From: Alison Meeus <[REDACTED]>
Sent: 04 July 2022 13:46
To: Anita Gardner <Anita.Gardner@arun.gov.uk>
Subject: RE: [EXTERNAL] RE: A/268/21/PL #

Hi Ben - thanks for this, can you confirm where the footway your designer has agreed to will be on drawing 2021/5891/002, as its not clear where it is still.

Drawing title  
Site Plan

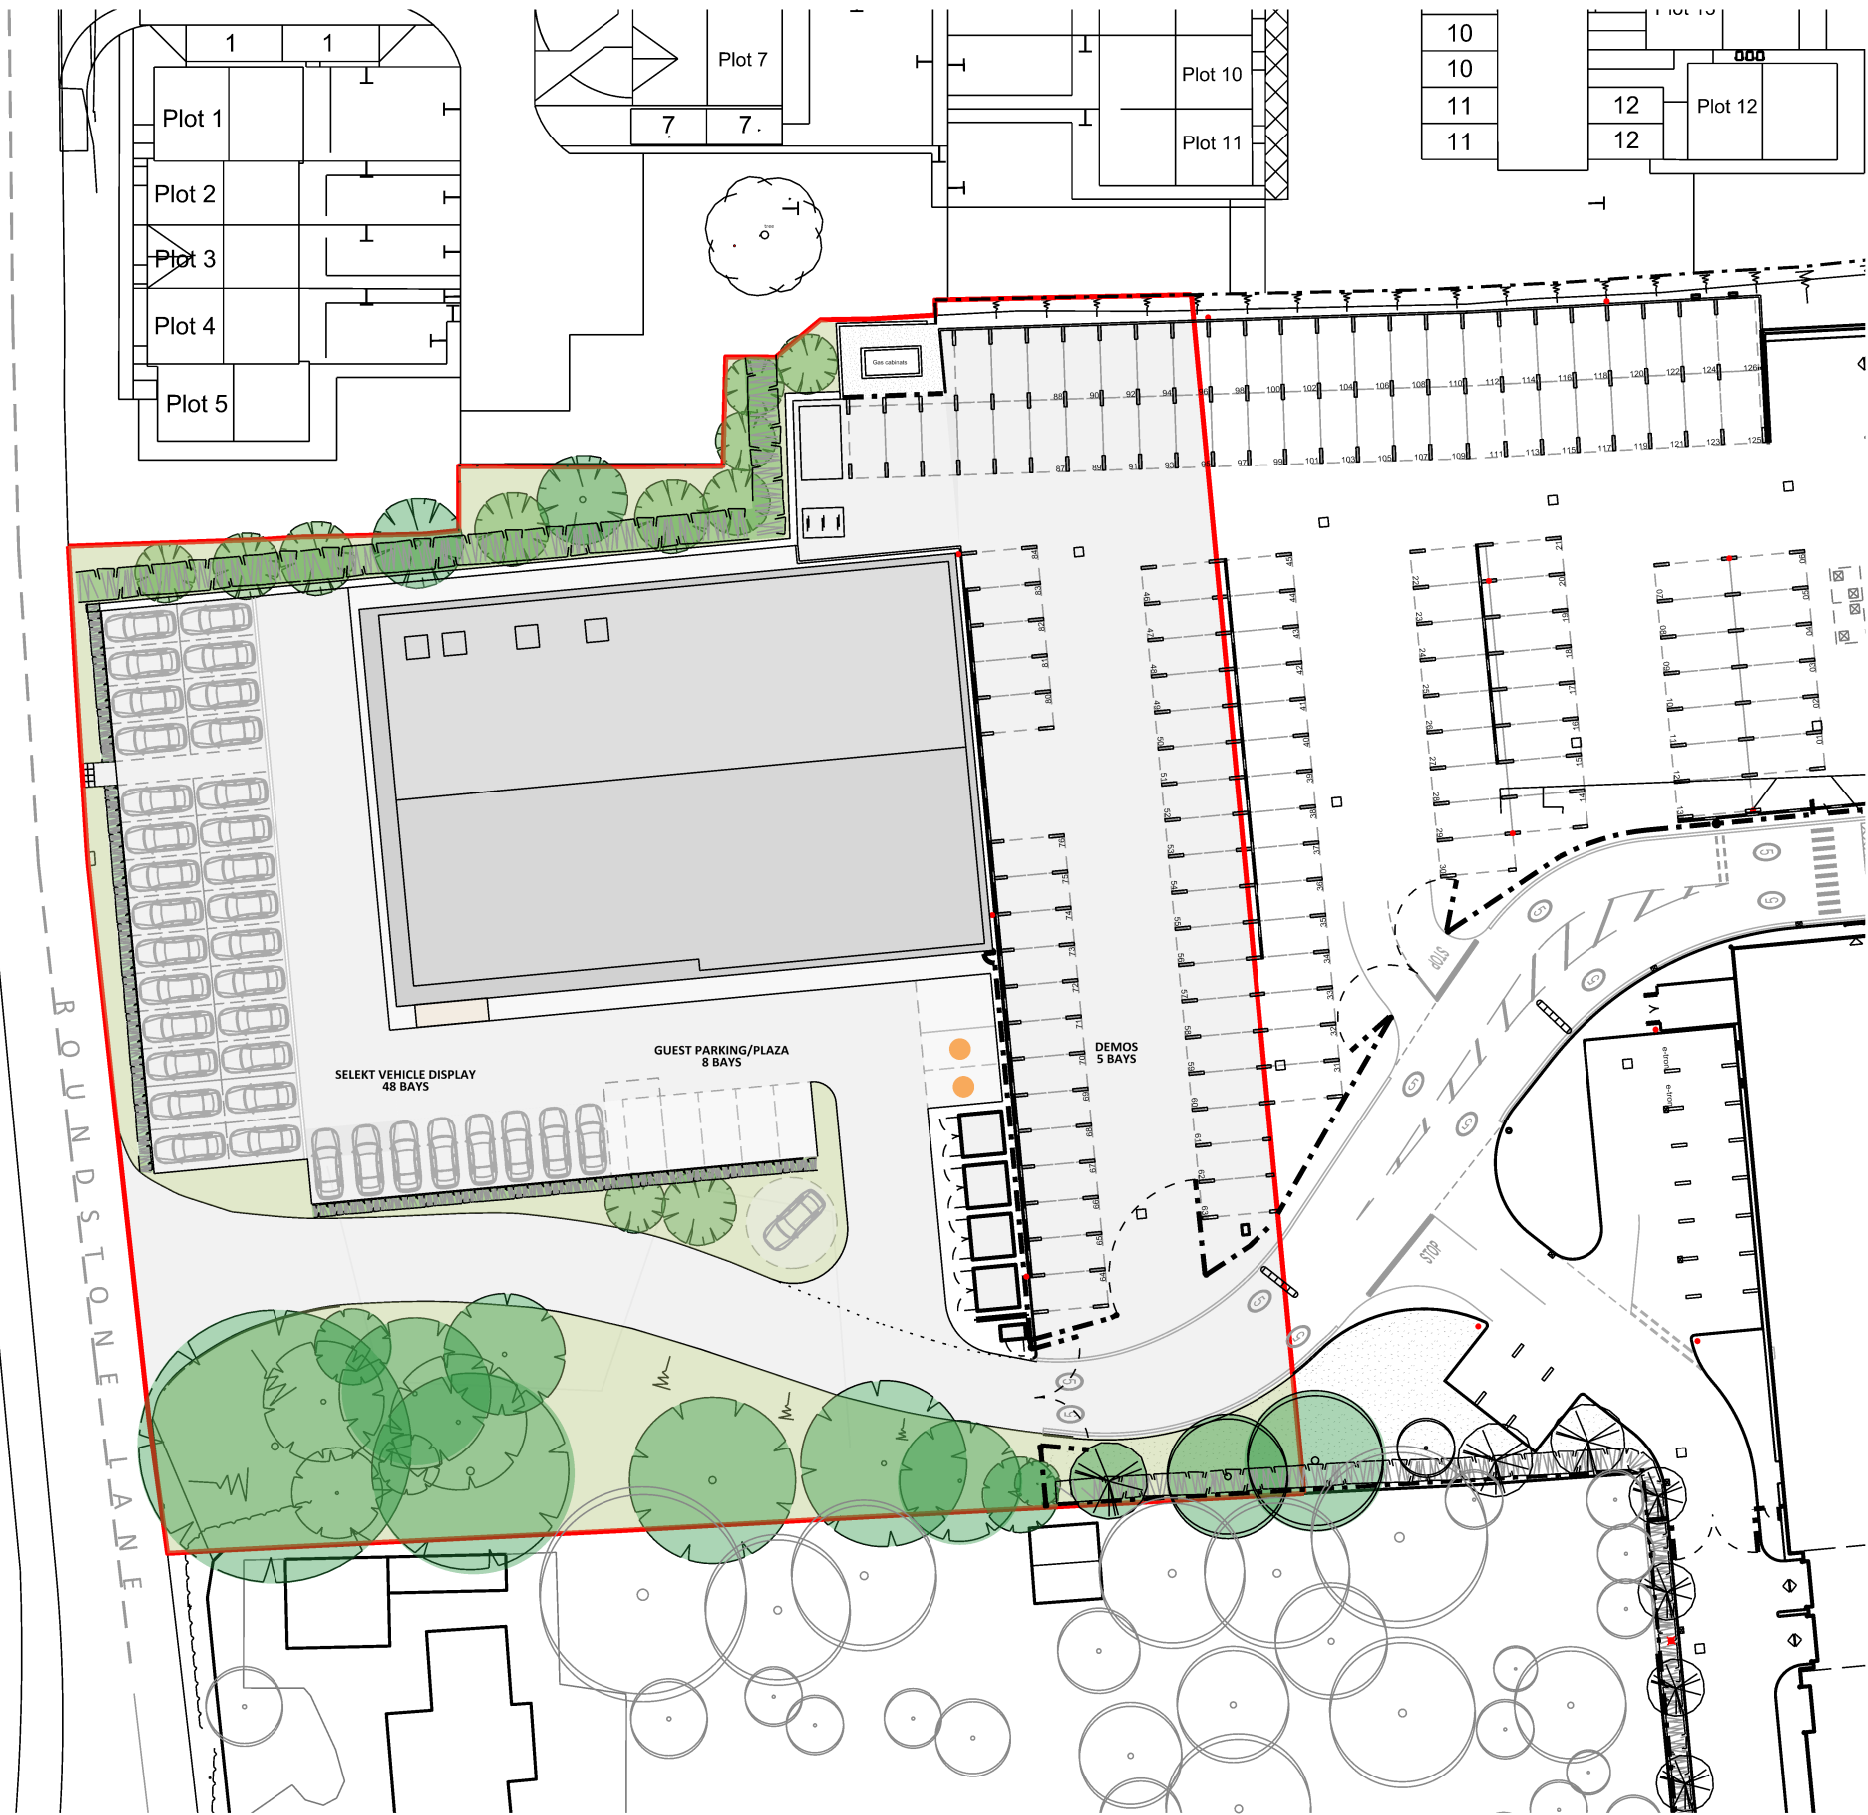
Whilst a dropped kerb is not linking to a footway on the other side, consideration needs to be given to how pedestrians will be guided in a southbound direction, especially if they are mobility impaired. Perhaps a dropped kerb on the other side (western side) to line up with one here?

Thanks Ben - will there be a dropped kerb with tactile paving at the bell mouth? I see there is no footway on the other side of the road which could link into the new footway as part of the a259 improvement works. Would you be extending this over to meet this footway?

I can see the connection into the site via a dropped kerb but I am unsure of the extent, does it extend to the kerb radii of the access or does it start at the pedestrian access to the car shown room and extend to the north to meet the existing footway here by the southbound bus stop??

I completely agree with the below approach which is why have already proposed to include a dropped kerb to the western footway, please see attached and below.

We haven't shown dropped kerb/ tactile paving at the bell mouth because as you mention there is no footway south of the site to tie into.

Please see attached site plan with the footway highlighted in grey against the green back of footway that shall remain grass verge within WSCC control.
